Arun District Council
Arun Civic Centre
Maltravers Road
Littlehampton
West Sussex BN17 5LF
Planning & Building Control General Enquiries
Tel: (01903) 737756 Fax: (01903) 730442
Dx: 57406 Littlehampton
Minicom: 01903 732765
e-mail: planning@arun.gov.uk
website: www.arun.gov.uk/planning

Application No: LU/214/20/PL
Site Address: Empty Supermarket Premises Avon Road Littlehampton BN17 6AT
Description of works: Demolition of existing buildings & redevelopment comprising 37 No. residential units (Class C3) & flexible commercial floorspace (Class A1, A2, A3 and/or D1) together with the provision of car & cycle parking, landscaping & associated works (resubmission following LU/3/19/PL). This application affects the setting of listed buildings & may affect the character & appearance of the East Street, Littlehampton Conservation Area. This application is in CIL Zone 4 (Zero Rated) as 'flats & other development'.

Thank you for your internet representation made on 5th November 2020 which has been recorded as an objection with the comments as follows:

Drawing Tittle
EXISTING
ELEVATION F

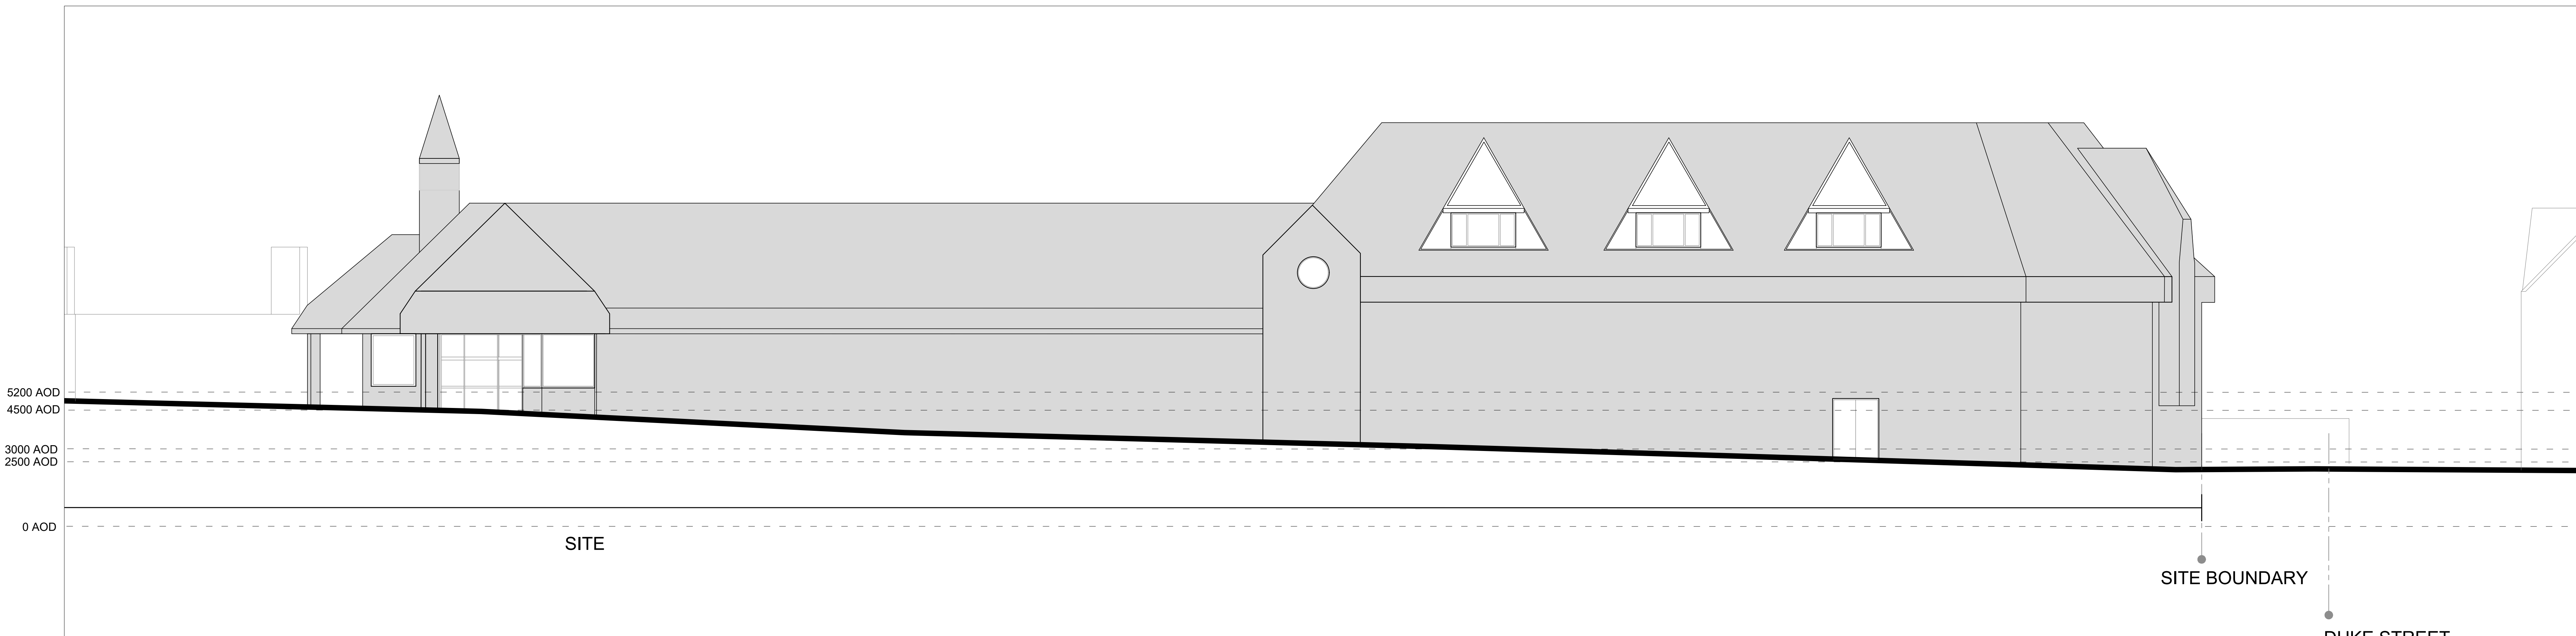
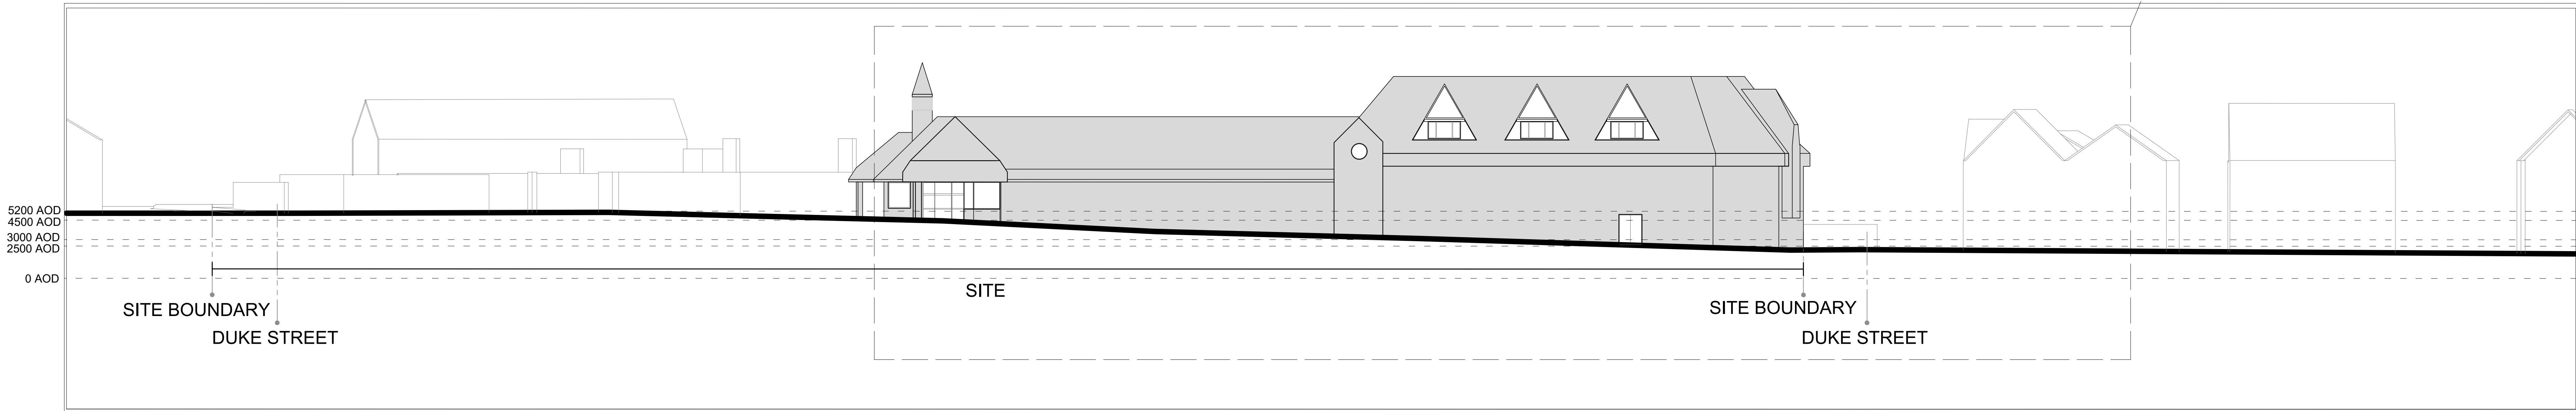
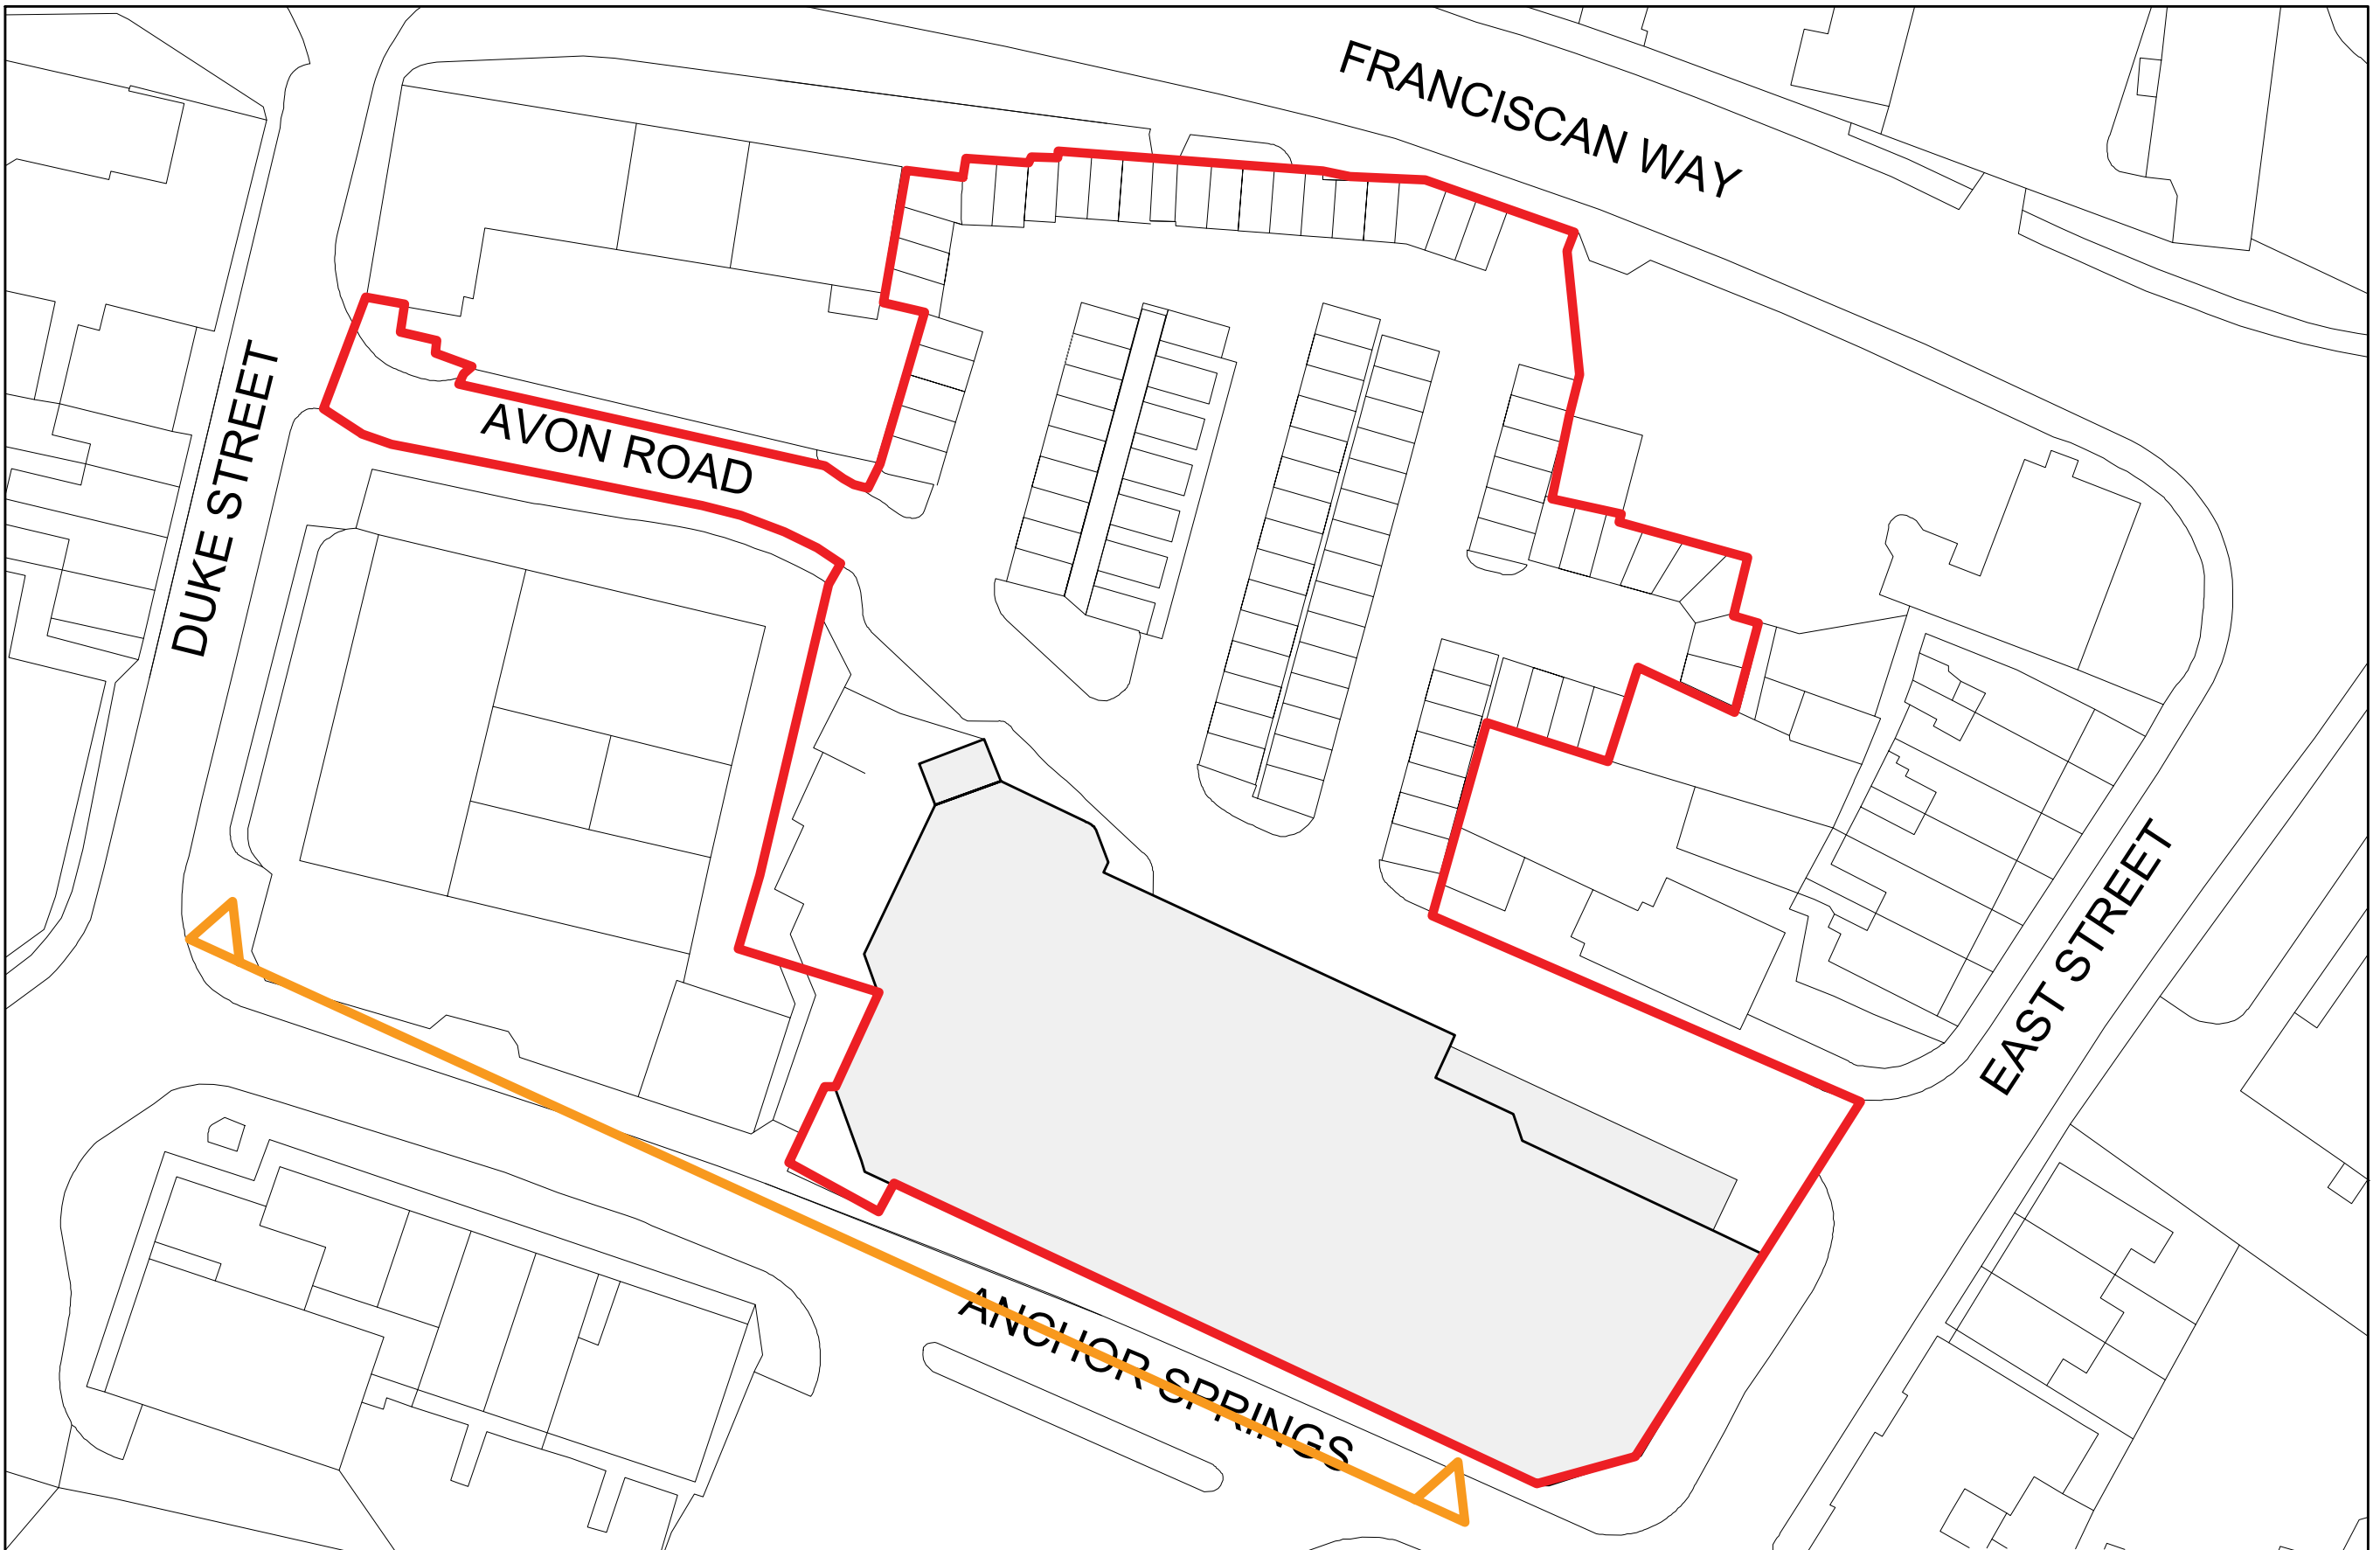
Existing Elevation F - ANCHOR STREET should be ANCHOR SPRINGS, Duke Street is both east and west of the proposed site.
